Please ask for: Ms Iqraa Malik
Email: iqraa.malik@terraquest.co.uk
Telephone: 01212341390
Our Ref: R/66/21/HH
Your Ref:
Date: 1st April 2021

Application for Planning Permission for Works or Extension to a Dwelling

Development: Demolition of existing side lean-to extension and construction of single storey rear extension
Location: 30 Harsfold Road Rustington BN16 2QE

block plan

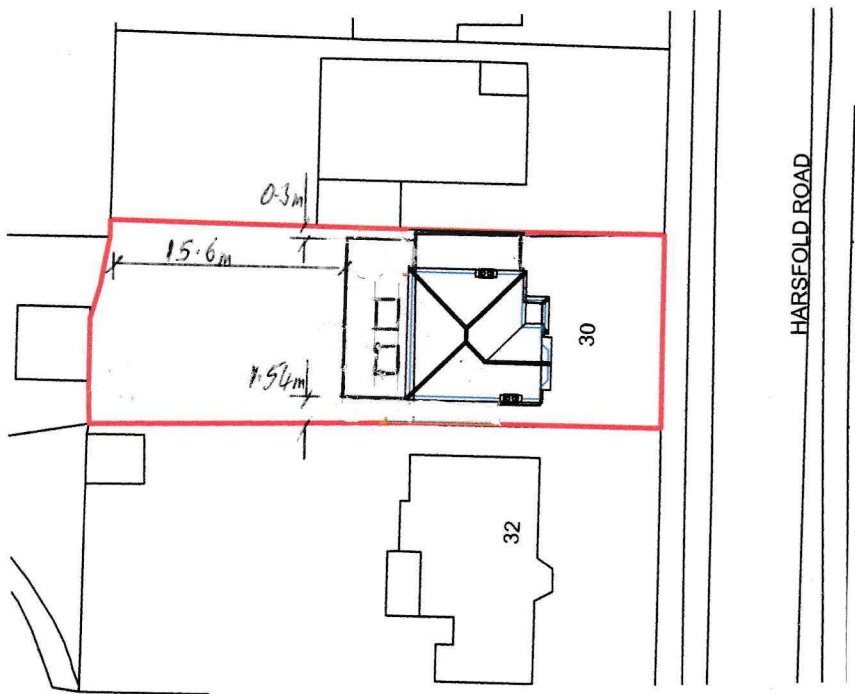
Block Plan

You are required to have dimensions from the proposed extension(s) to all site boundaries. Please amend.
